NSW RURAL FIRE SERVICE

Your reference: SSD 10436
Our reference: DA20200520001740-EIS & DA
Exhibition-1

State Significant Development – Warehouse or Distribution Centre
Request for comments – exhibited Environmental Impact Statement (EIS)
ESR Horsley Logistic Park (SSD-10436) 6 Johnston Crescent Horsley Park NSW, (none)

DRAWING TITLE  
ESTATE MASTERPLAN  
DRAWING NUMBER  
200226 - DA - MS-A010  
DRAWN  
AB  
CHK  
HL  
ISSUE

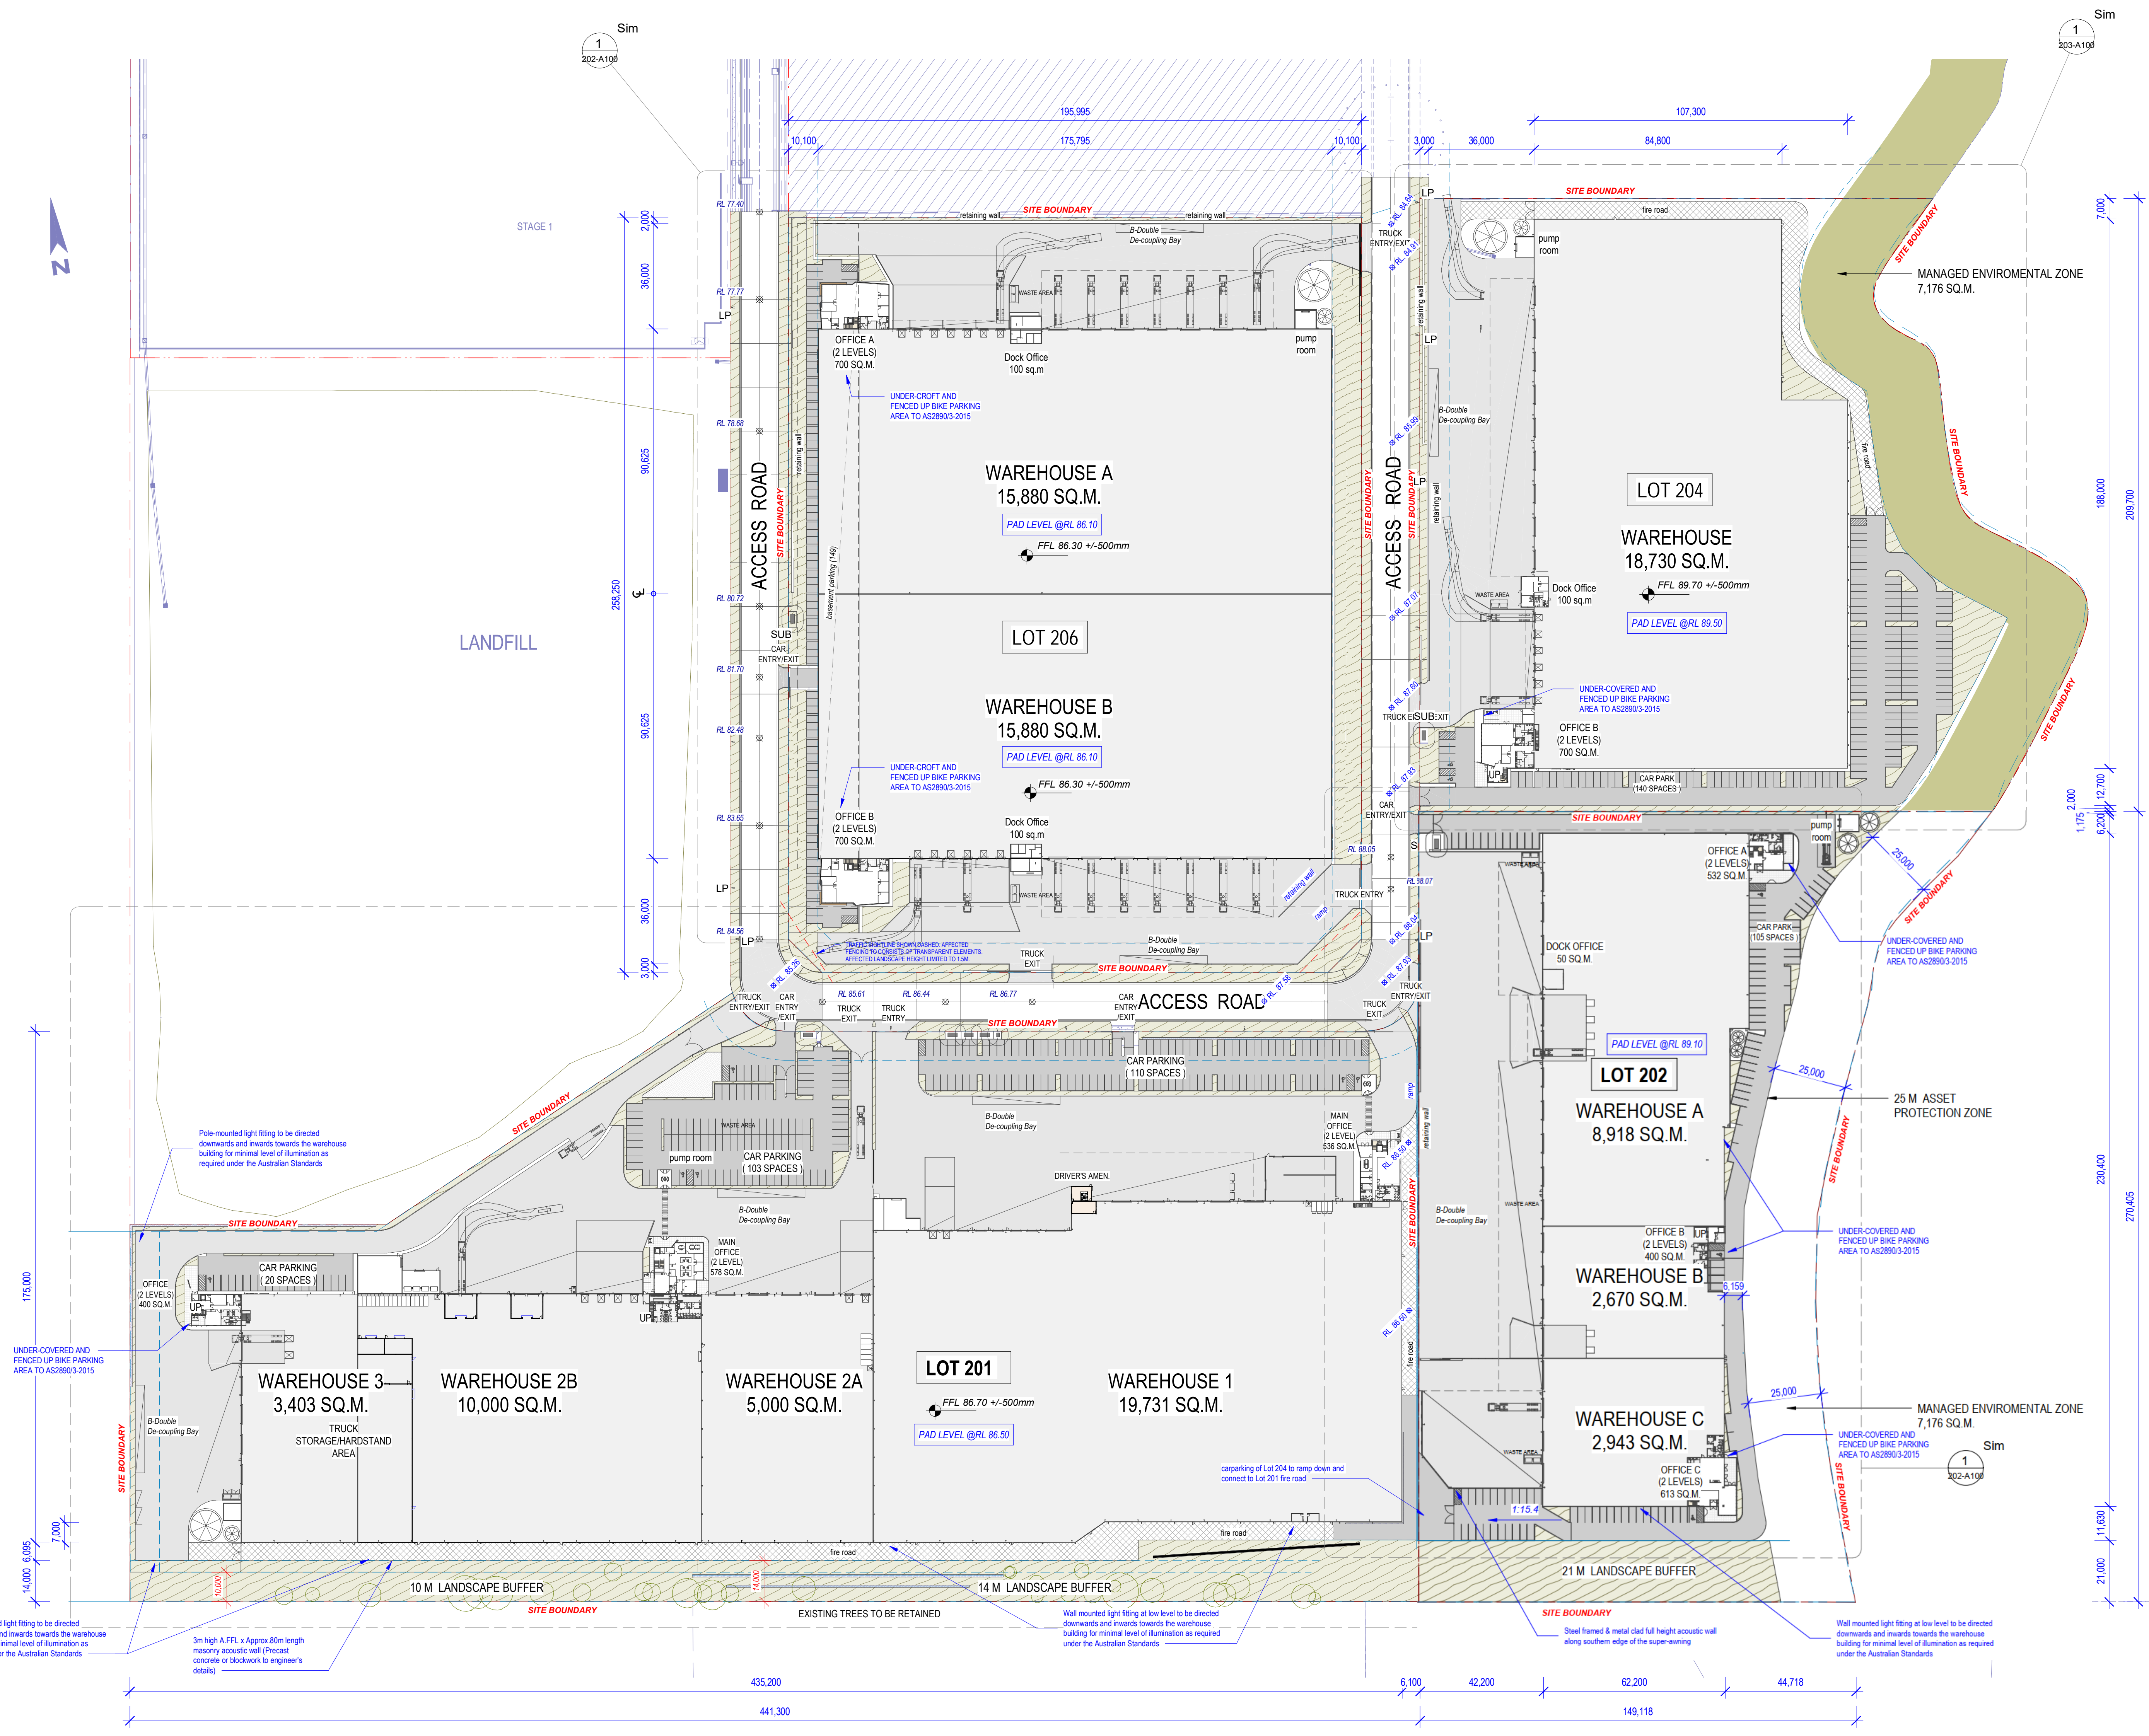
1. From the start of building works and in perpetuity, Lots 201 to 204 and the landfill site must be entirely managed as an inner protection area (IPA) in accordance with the requirements of Appendix 4 of *Planning for Bush Fire Protection 2019*. When establishing and maintaining an IPA, the following requirements apply:

2. New construction of the proposed warehouse buildings on Lots 201, 203 and 204 must be non-combustible, and comply with Sections 3 and 5 (BAL 12.5) Australian Standard AS3959-2018 *Construction of buildings in bush fire-prone areas* or NASH Standard (1.7.14 updated) *National Standard Steel Framed Construction in Bushfire Areas – 2014* as appropriate, and Section 7.5 of *Planning for Bush Fire Protection 2019*.
